Planning Inspectorate reference: EN070008

APPLICATION BY CHRYSOOR PRODUCTION (UK) LIMITED (THE APPLICANT) FOR A DEVELOPMENT CONSENT ORDER FOR THE VIKING CCS PIPELINE (EN070008).

NOTIFICATION OF INTENTION TO SUBMIT AN APPLICATION FOR CHANGE REQUEST

Drawing Title  
**WORKS PLAN  
REGULATION 5(2)(j)  
APPLICATION DOCUMENT REFERENCE 4.2  
SHEET 1 OF 36**

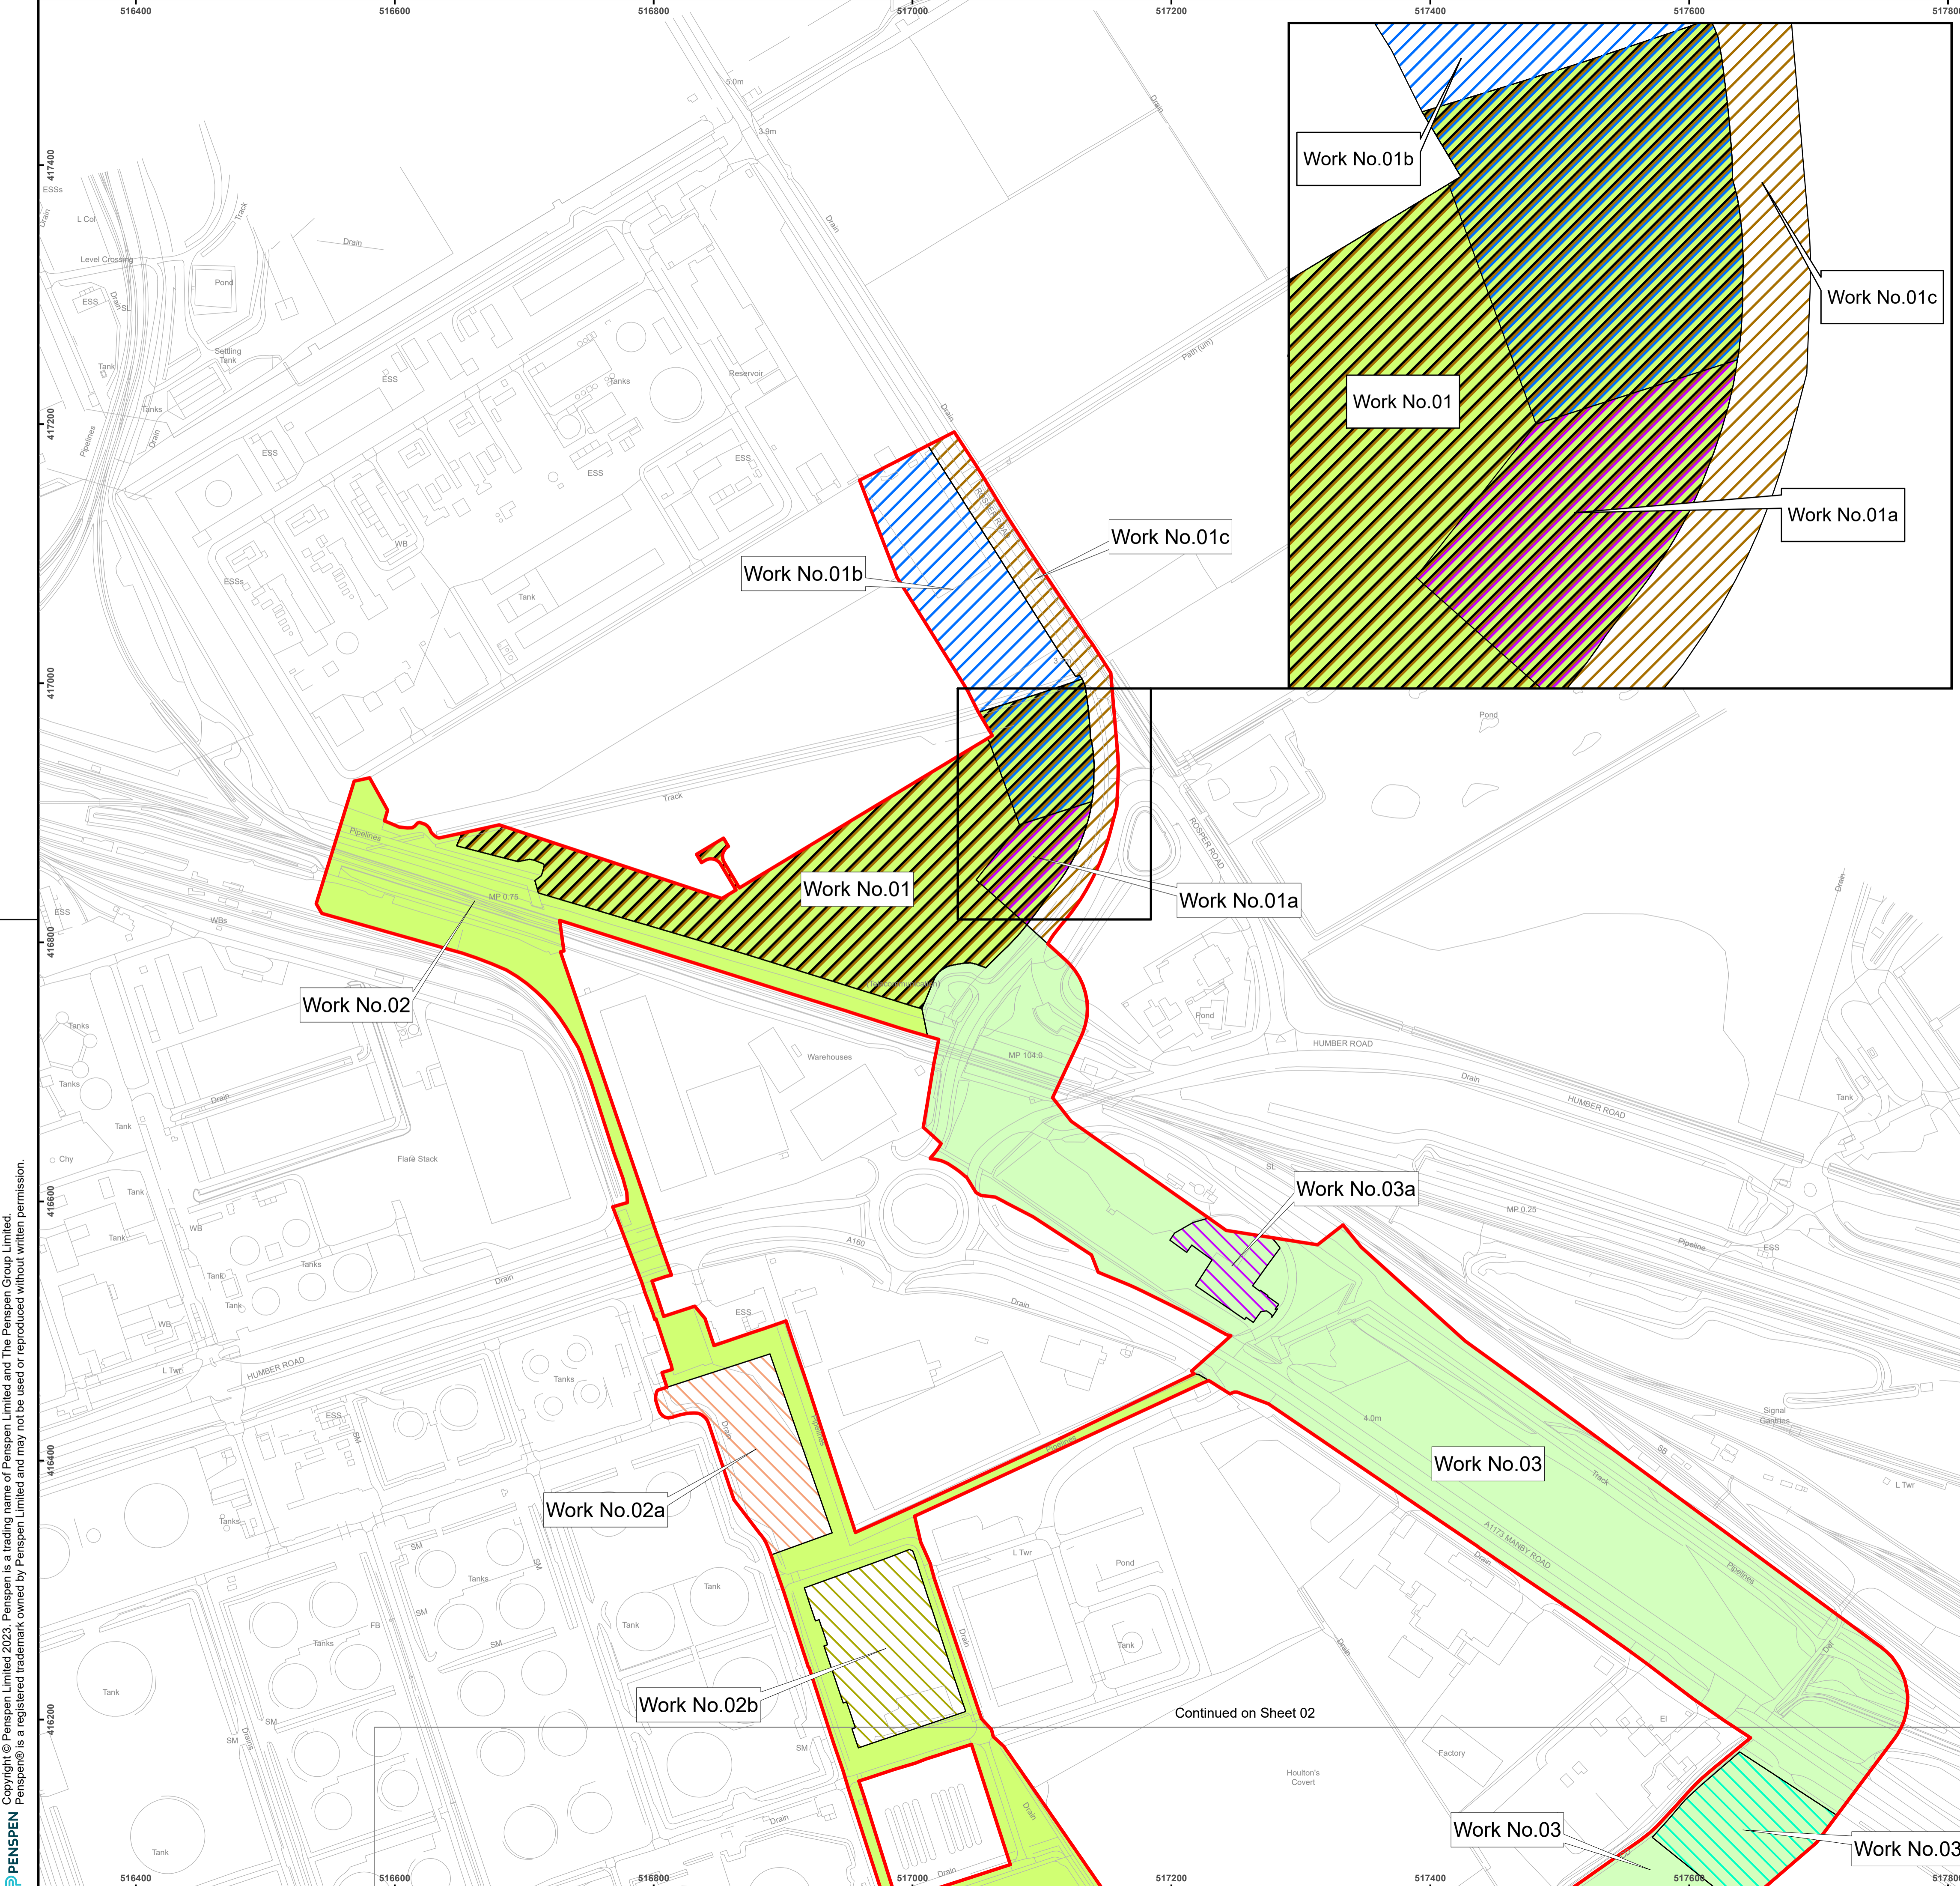
Change 1 – Modification and reduction of the Order Limits at Work No.01 (Permanent AGI Construction Works), Work No.01a (Permanent AGI Construction Works and Temporary Working Area), Work No.01b (Temporary and Permanent Access) and Work No.01c (Electrical Connection)

This change would result in alterations to the Order Limits associated with the above Works Nos. The change would reduce the area of land included in the Order Limits and would not engage any new land interests. No additional land outside of the current Order Limits is required. This change would not result in new or different likely significant environmental effects reported in the Environmental Statement.

Drawing Title  
**WORKS PLAN  
REGULATION 5(2)(j)  
APPLICATION DOCUMENT REFERENCE 4.2  
SHEET 2 OF 36**

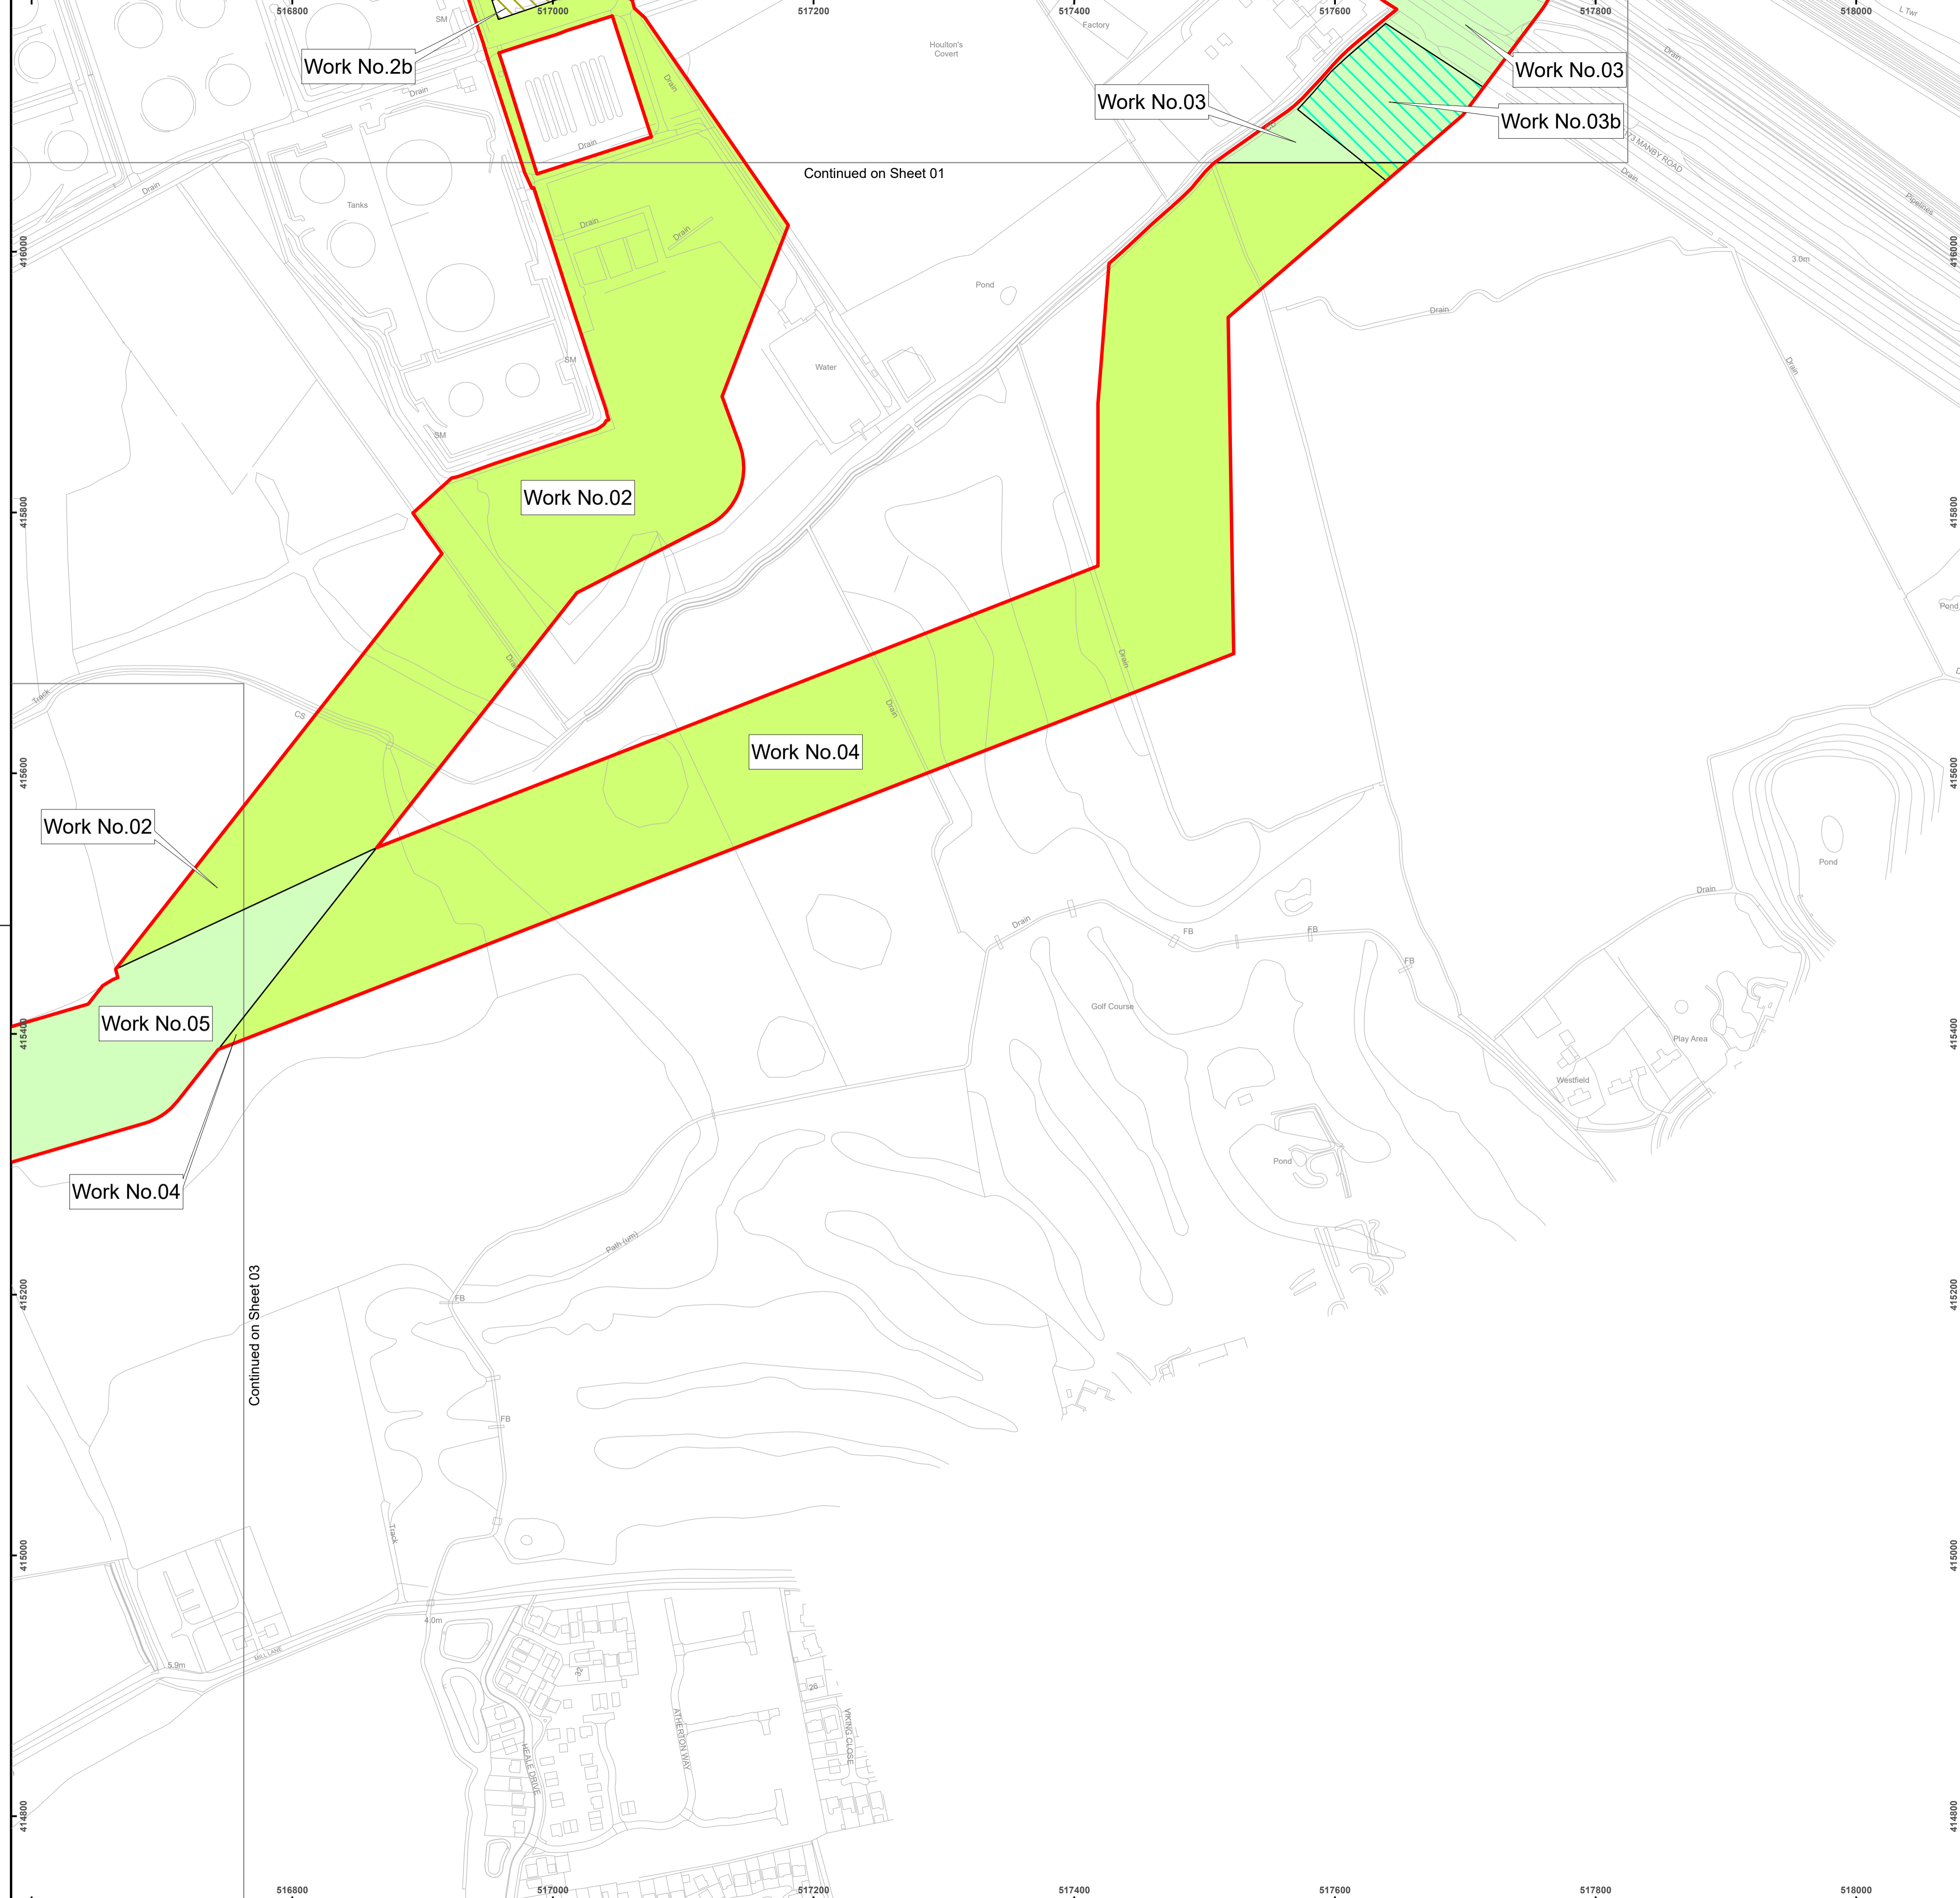
Change 2 – Removal of Work No.2 (Carbon Dioxide Pipeline Works), Work No.02a (Temporary Access & Laydown Location) and Work No.02b (Temporary Access & Laydown Location)

It is proposed that land to the west and south of the Immingham Facility will be removed from the Order Limits. Specifically, the following land plots would be removed or modified: 1/1, 1/2, 1/3, 1/4, 1/5, 1/6, 1/7, 1/8, 1/9, 1/10, 1/11, 1/12, 1/13, 1/14, 1/15, 1/16, 1/17, 1/18, 1/19, 1/20, 1/21, 1/22, 1/23, 1/24, 1/25, 1/26, 1/27, 1/28, 1/29, 1/30, 1/31, 1/33, 1/34, 1/35, 1/38, 1/39, 1/68, 1/69, 1/70, 2/2, 2/6, 2/8, 2/10, 2/11.

This change would result in alterations to the Order Limits and would reduce the area of land included in the Order Limits. It would not engage any new land interests. This change will not result in new or different likely significant environmental effects reported in the Environmental Statement.
